# Bramford to Twinstead Reinforcement

Document 2.11.12 (B): Design and Layout Plans: Temporary  
Bellmouth For Access

Final Issue B  
October 2023

Date	Issue	Status	Description / Changes
April 2023	A	Final	For DCO submission
October 2023	B	Final	This document has been updated to amend the sight line following discussions with Essex County Council and Suffolk County Council on 13 October 2023

TITLE  
 2.11.12(B) Design and Layout Plans:  
 Temporary Bellmouth for Access

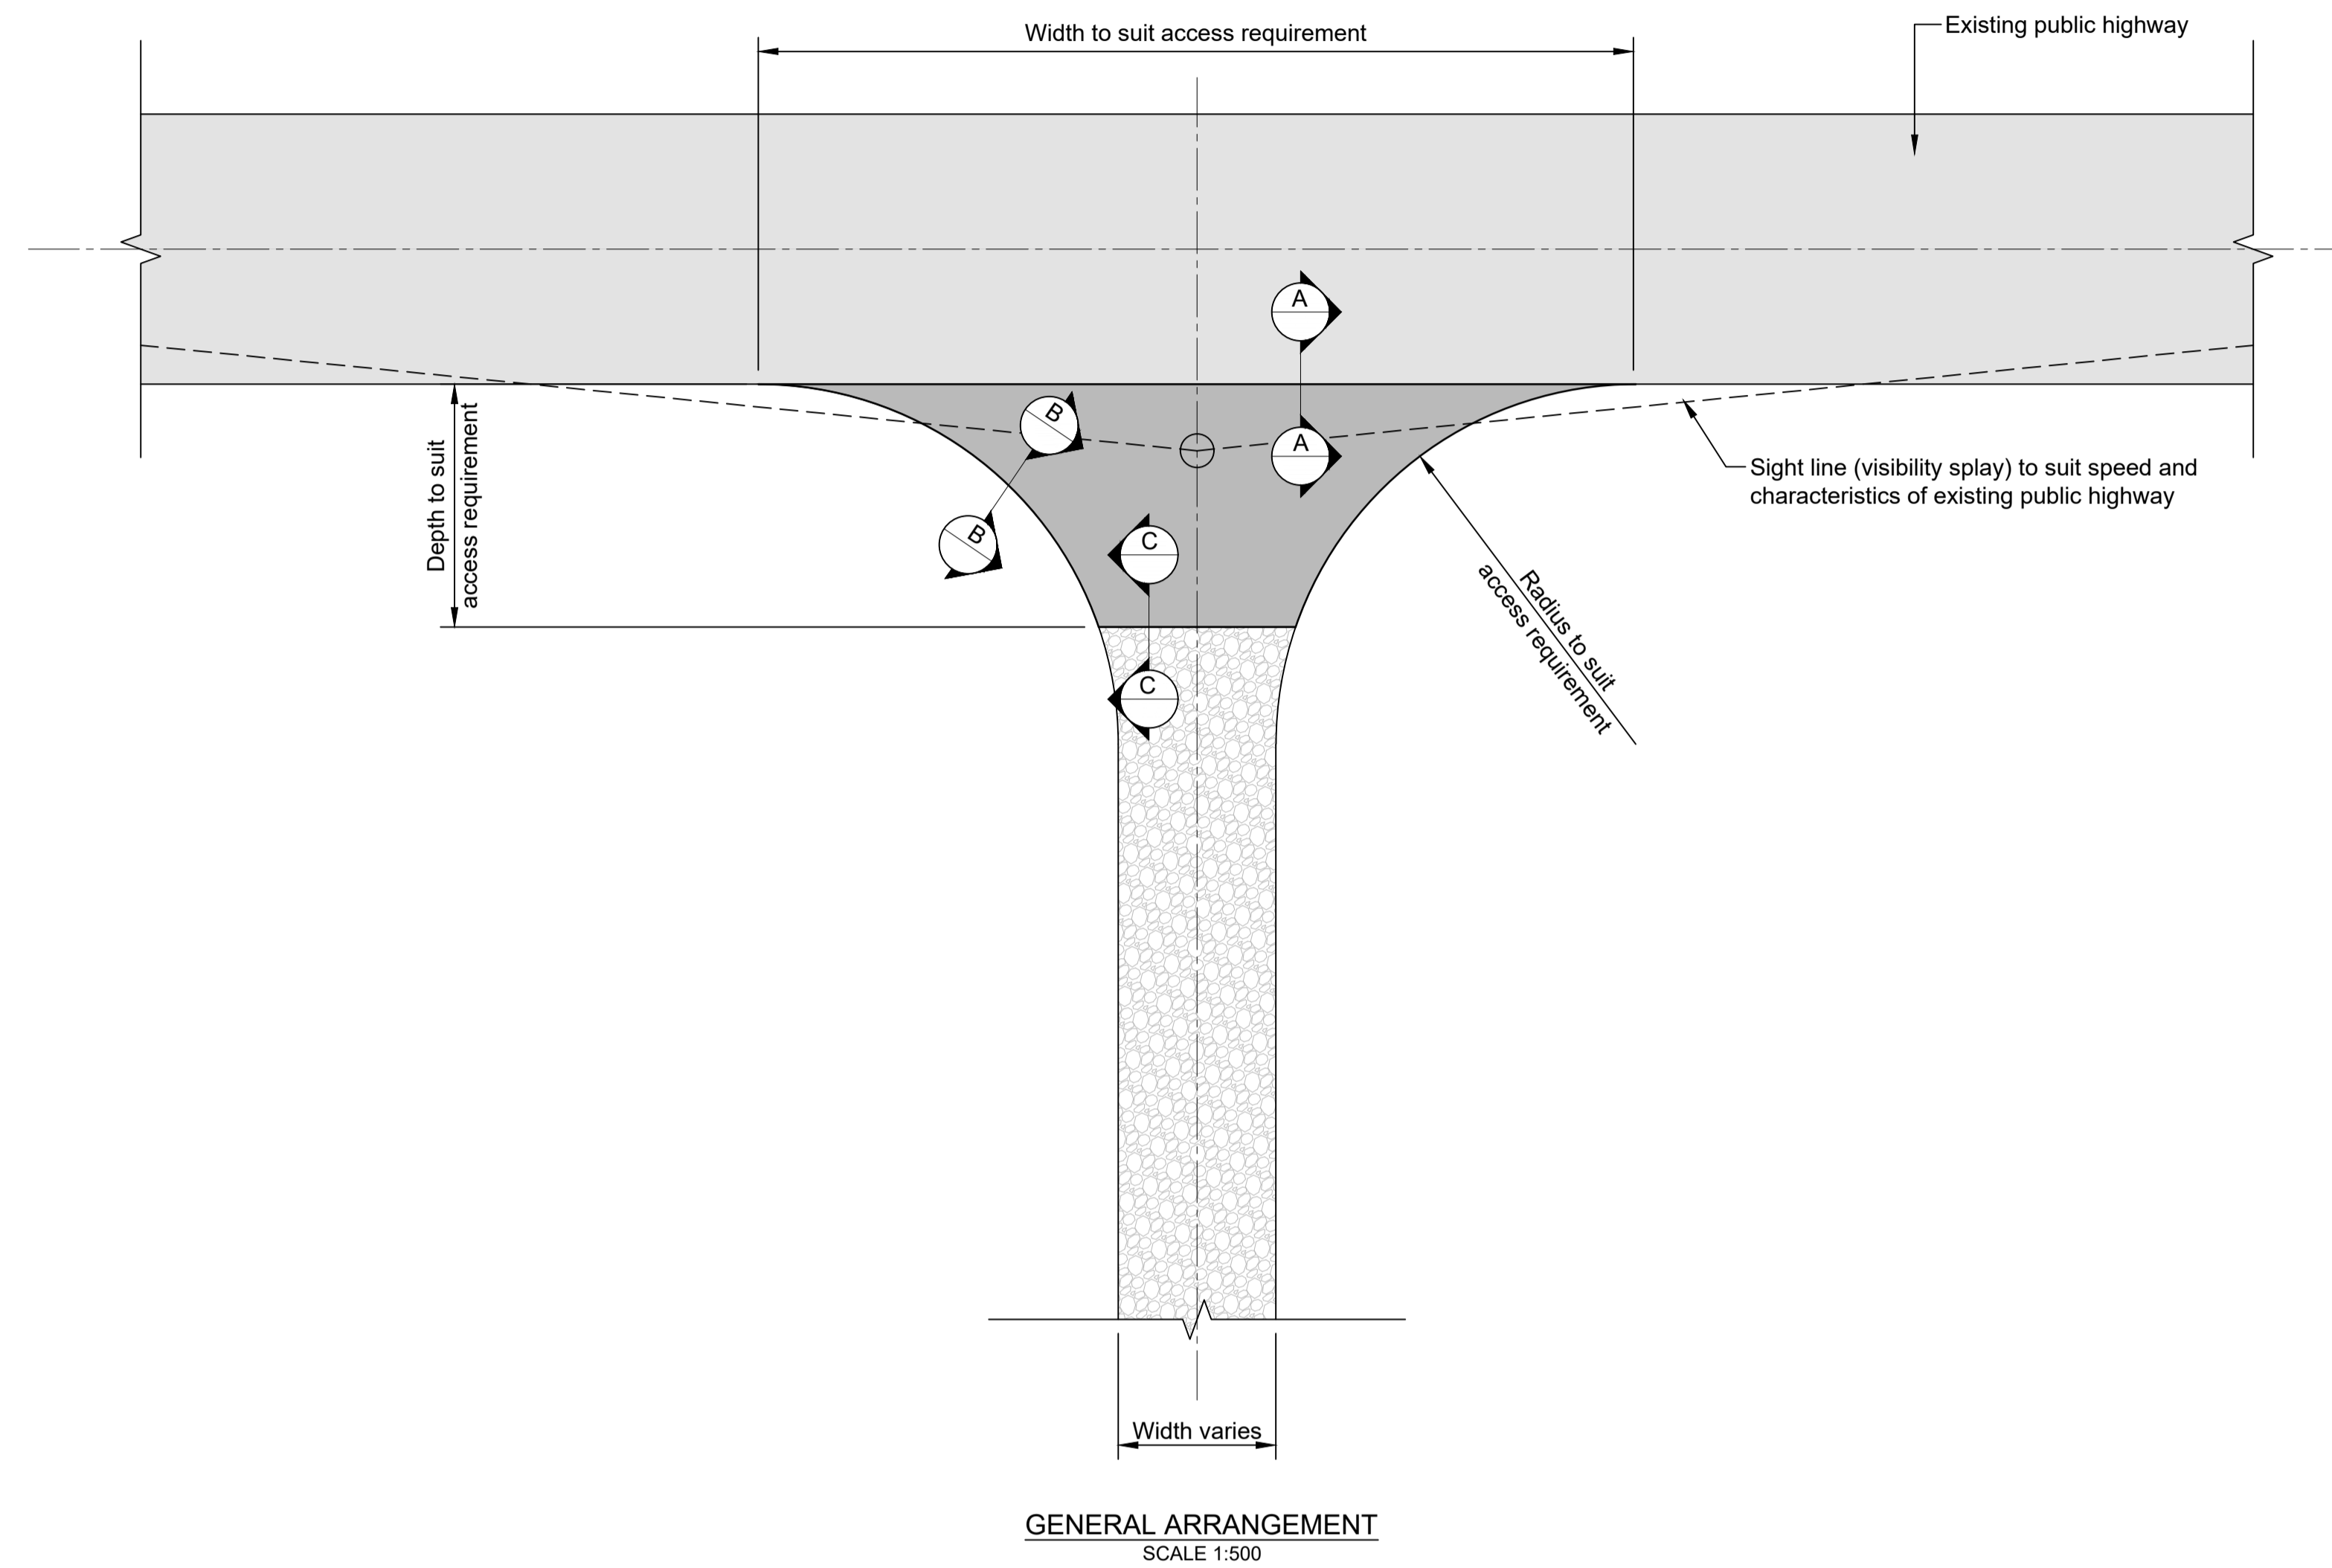
ISSUE	DATE	REMARKS	DRAWN	CHKD	APPD
B	25/10/23	Update to sight line for Deadline 3	NP	DF	RF
A	17/02/23	Rev A for DCO Application	NP	DF	RF
